Red Text = The El Paso County Comments Rev. 1

Green Text = The Engineer of Record answers on the El Paso County Comments Rev. 0 for Variance of Use project

1185 N Curtis Rd, Colorado Springs, CO 80930

PROJECT NAME:
**VARIANCE
OF LAND USE**

PROJECT NAME:  
 VARIANCE OF LAND USE  
 PROJECT ADDRESS:  
 1185 N Curtis Rd,  
 Colorado Springs,  
 CO 80930  
 PARCEL NUMBER:  
 4410000052  
 SHEET NUMBER:  
 S-3

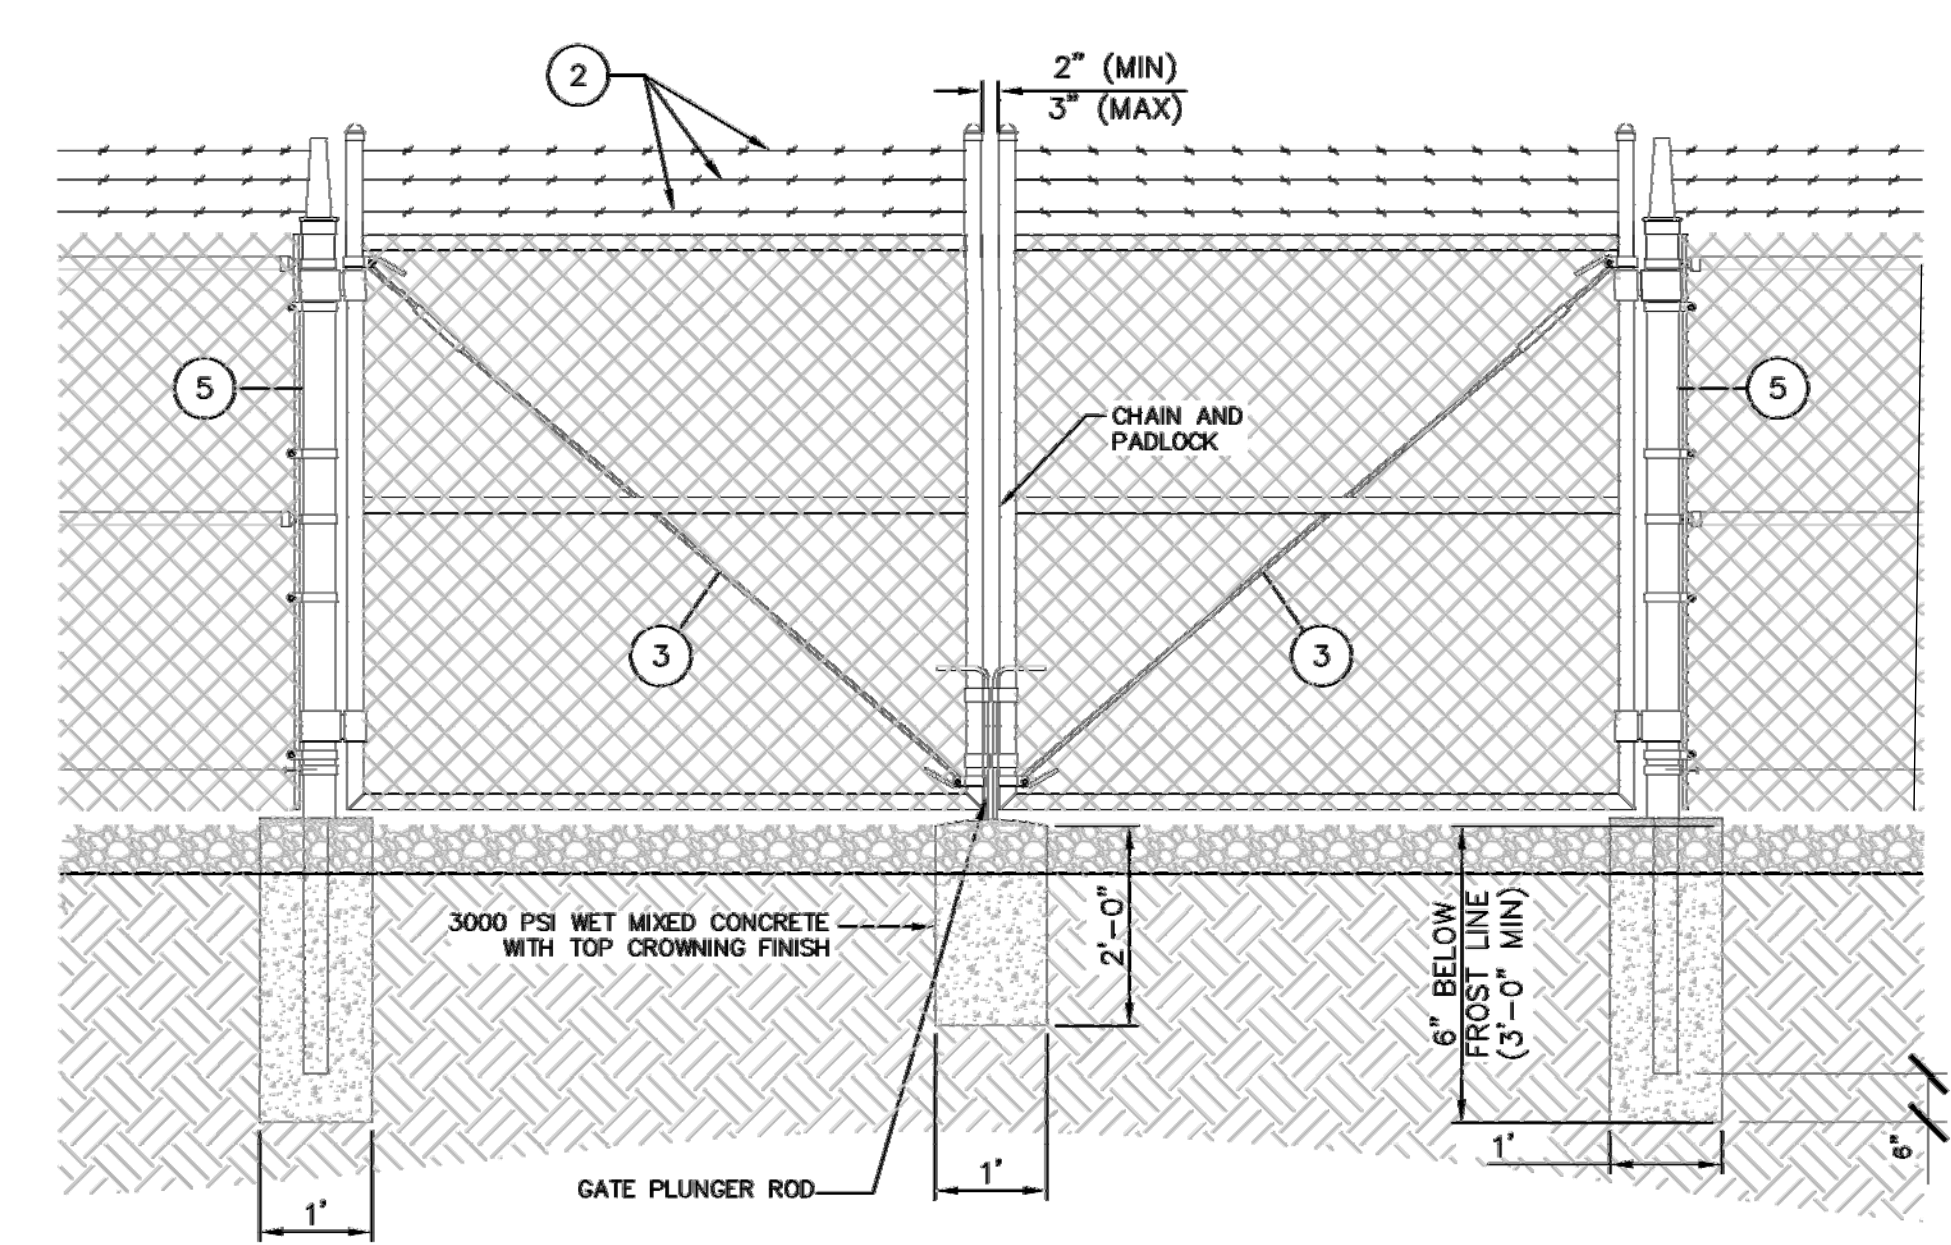
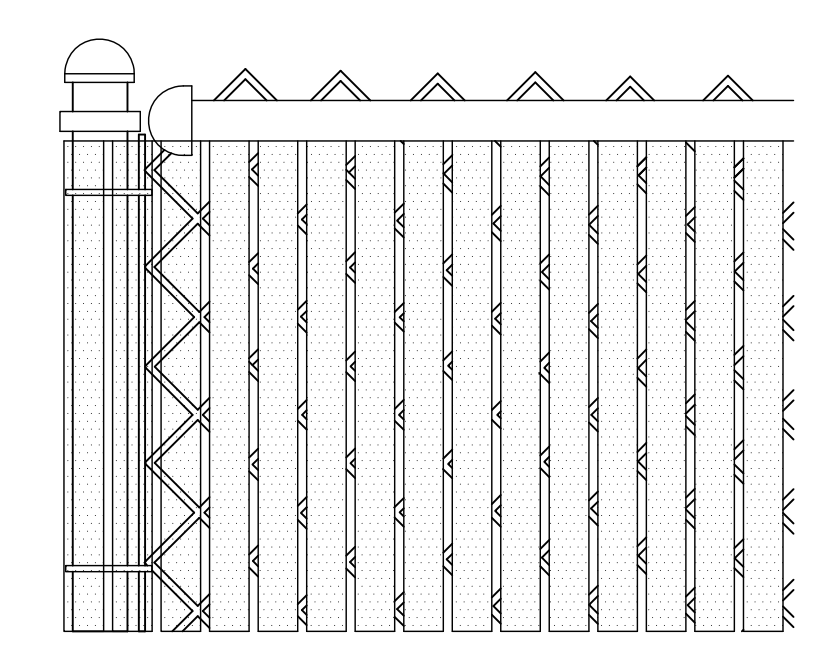
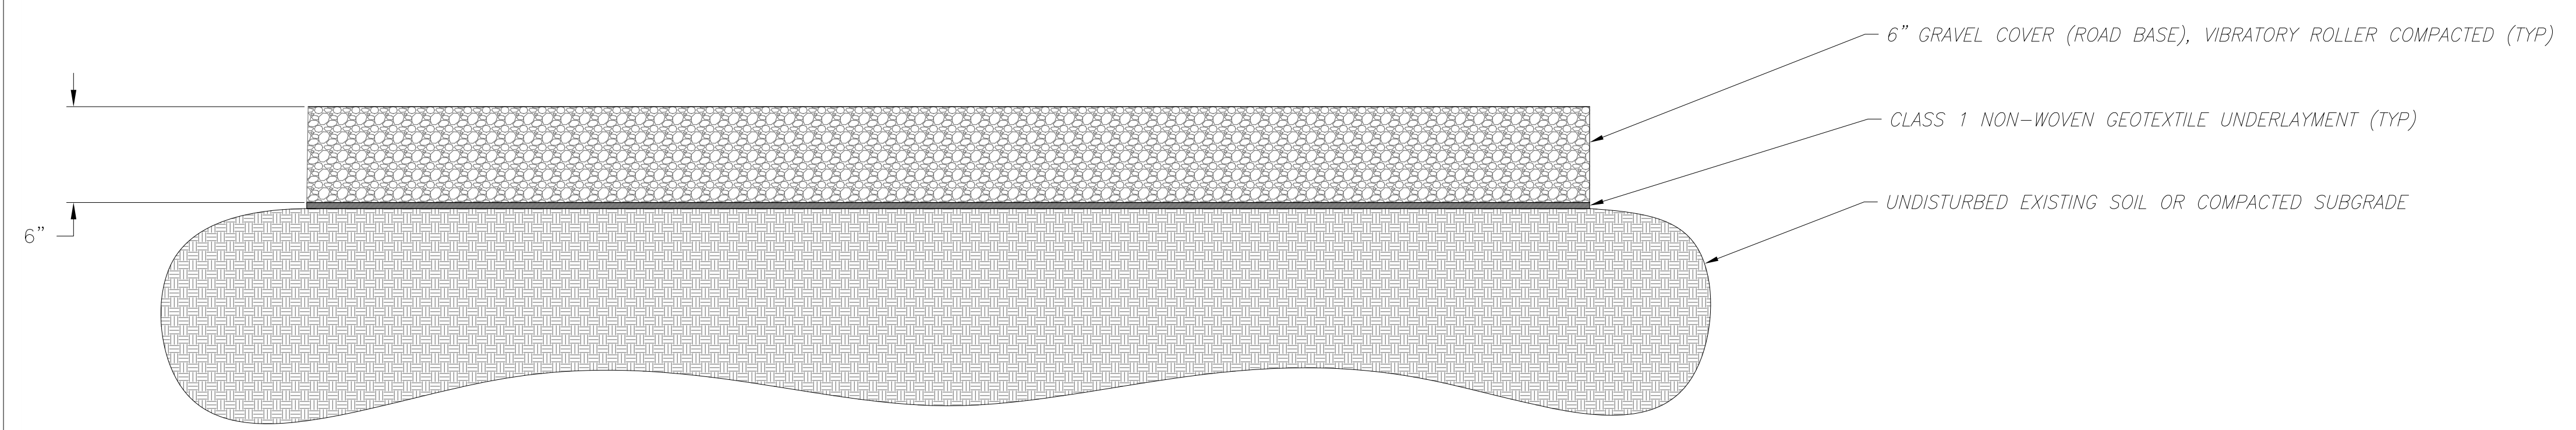
6. Anything over 7 ft will require a separate building permit
✓ Corrected. There is nothing on the fence taller than 7 feet. Therefore, no need for a separate building permit as presented on Sheet #: S-3.
